Our Ref: **P/DC/3/3/21**

Your Ref: **ABP-309893-21**

Re: **Observations on Appeal ABP-309893-21 PA Ref. P/DC/3/3/21**

**Applicant:** Advanced Vision Limited.  
**Site Address:** The Dean Hotel, Bohermore, Galway.  
**Description:** Relocation of Electricity Substation.

FIGURE (i) Extract from Site Layout Map (Drawing No. W: 16 JOBS P-S-250A lodged with reply to Further Information on 4th of July 2017. It shows the car park 13 spaces required. It shows the dimensions of the ESB Substation from the Boundary wall and the house of No. 6 Forster Court.

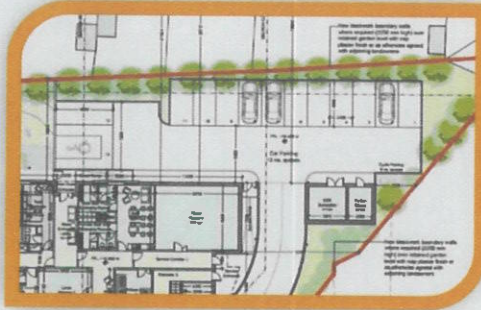
The relocation of the substation to within 1.0m of the rear of No 6 Foster Court has resulted in the imposition of a structure 5.0m higher than the ground level of no 6 Forster Court within 5.35m of the rear wall of the property which is a single storey bungalow. The Planning Authority do not consider that the proposed planting in the gap between the boundaries will significantly mitigate the impact of this overbearing structure even if the planting manages to become established in these inhospitable conditions.
